“ATTENTION: DIRECTOR, INFRASTRUCTURE PROJECTS”
DEPARTMENT OF PLANNING AND INFRASTRUCTURE
Resident Submission: NWRL EIS2 Application Number: SSI-5414

Application Name:
“Joy Bull - Resident Submission NWRL EIS 2 – Cherrybrook Traffic Management”

3. Application Number: SSI-5414

Figure 6.12 Cherrybrook Station - Indicative vehicle and pedestrian movements

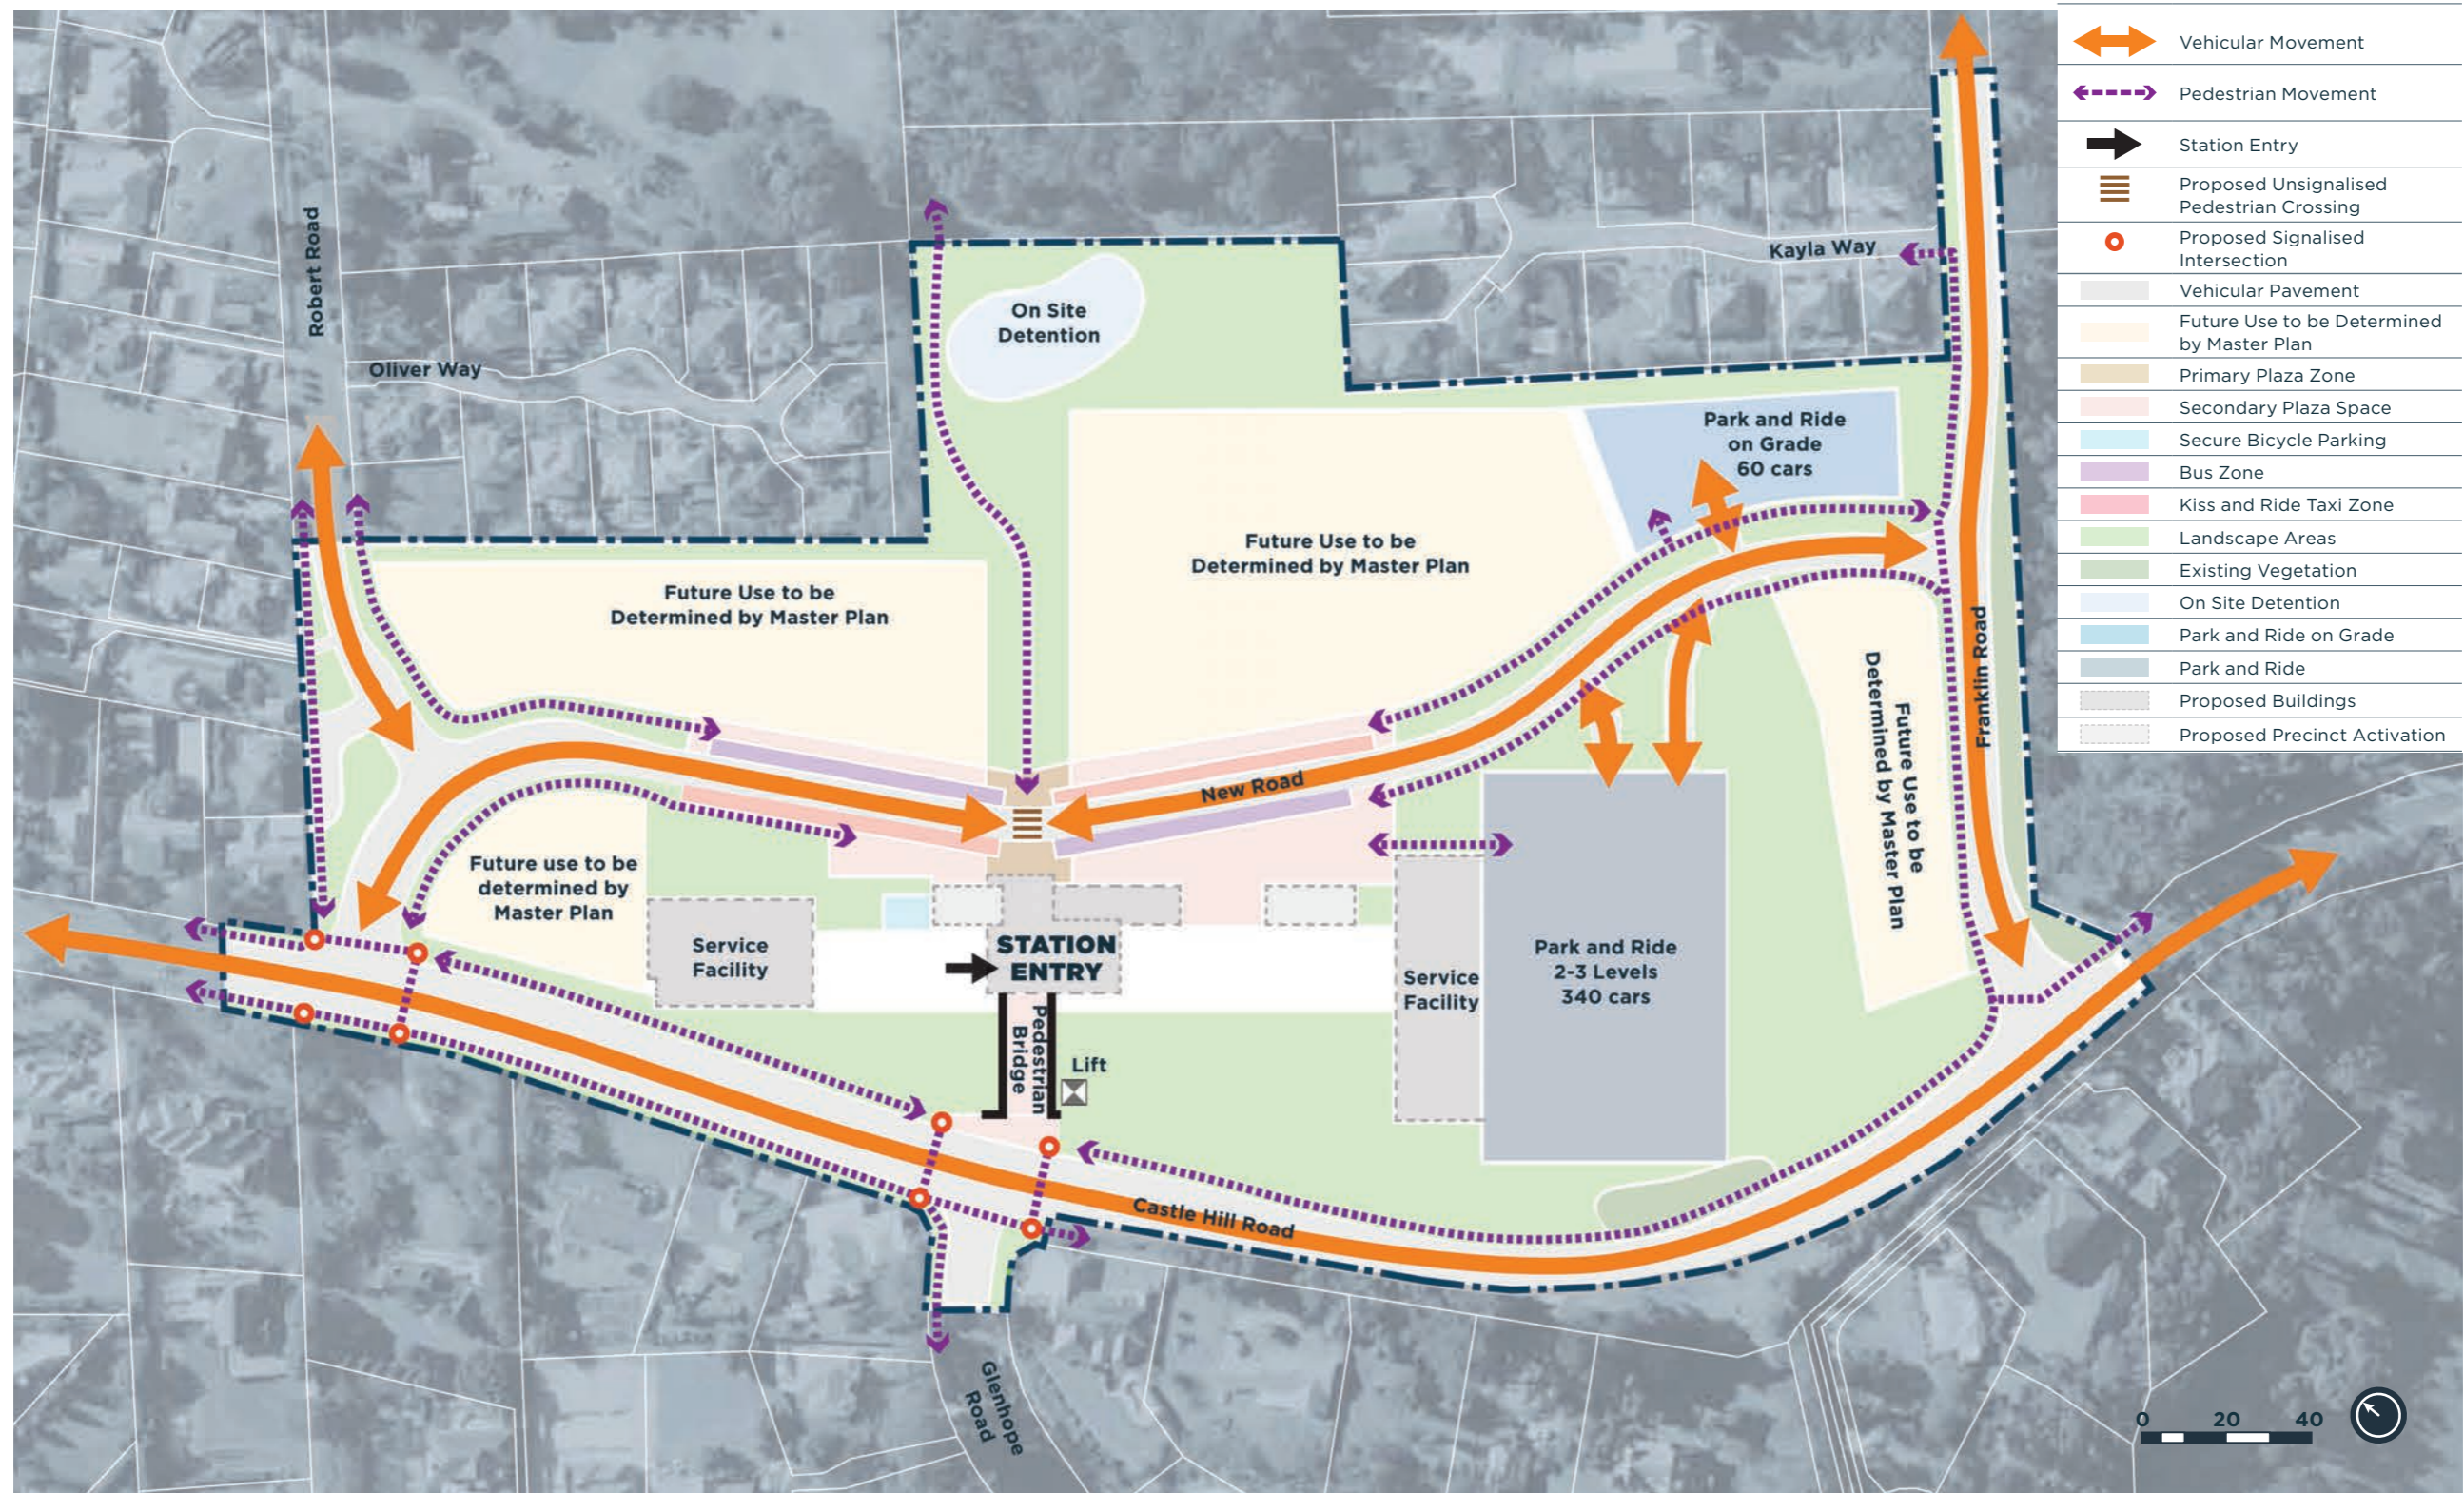
Robert Road would become an unworkable traffic bottleneck

Proposed “no parking” in Robert Road is unacceptable. Arundel Way has no guest and service vehicle parking on site. Other Private Roads would be similarly affected.

Dalkeith Road and the dead end roads that flow into it would become a bottleneck for residents entering and exiting their homes should Robert Road become the primary suburban feeder road to Cherrybrook Station.

At the recent information afternoon held at Castle Hill a representative of the NWRL advised that the current bus route which travels south along County Drive, east up John Road and right into Franklin Road and left into Neale Avenue would be changed to accommodate passengers wishing to leave the bus at the new Cherrybrook Station. The new arrangements would be that after buses enter John Road, they would turn right into Robert Road, continue through to the back of the new station along the yet unnamed road behind the station, left into Franklin Road and would resume the normal route down Neale Avenue and right into Edward Bennett Drive.

I do not believe anyone from NWRL has travelled on the 642(x) route. If they had, they would have noticed that it will be extremely dangerous for buses to be travelling both ways down Robert Road at any one time. The road is extremely narrow and there have been many documented stories of head on collisions, cars cutting the corner when turning from John Road into Robert Road and no proper pedestrian footpaths for those walking along Robert Road (except in some newer sections).

- a) Close Robert Road at the existing dog leg so that all traffic north of that dog leg will have to exit to Castle Hill Road by driving north along Robert Road and then turning right or left at the intersection of John Road. This will have the effect of stopping “rat running” through a very narrow Robert Road to Cherrybrook Station and will cut down the number of cars exiting Robert Road either into the station precinct or onto Castle Hill Road.

- b) Use County Drive as the main bus route for the 642(X) bus (a small inconvenience for those people catching the bus in John Road).
- c) Widen Castle Hill Road travelling east from County Drive by providing a bus only lane down to Cherrybrook Station.

- d) Do not proceed with the new road behind the station, but rather make the new road in front of the station (moving the station further north between Robert Road and Franklin Road) with an entrance and exit at each end, parallel with Castle Hill Road – similar to the existing bus hub found on Epping Road at Lane Cove.
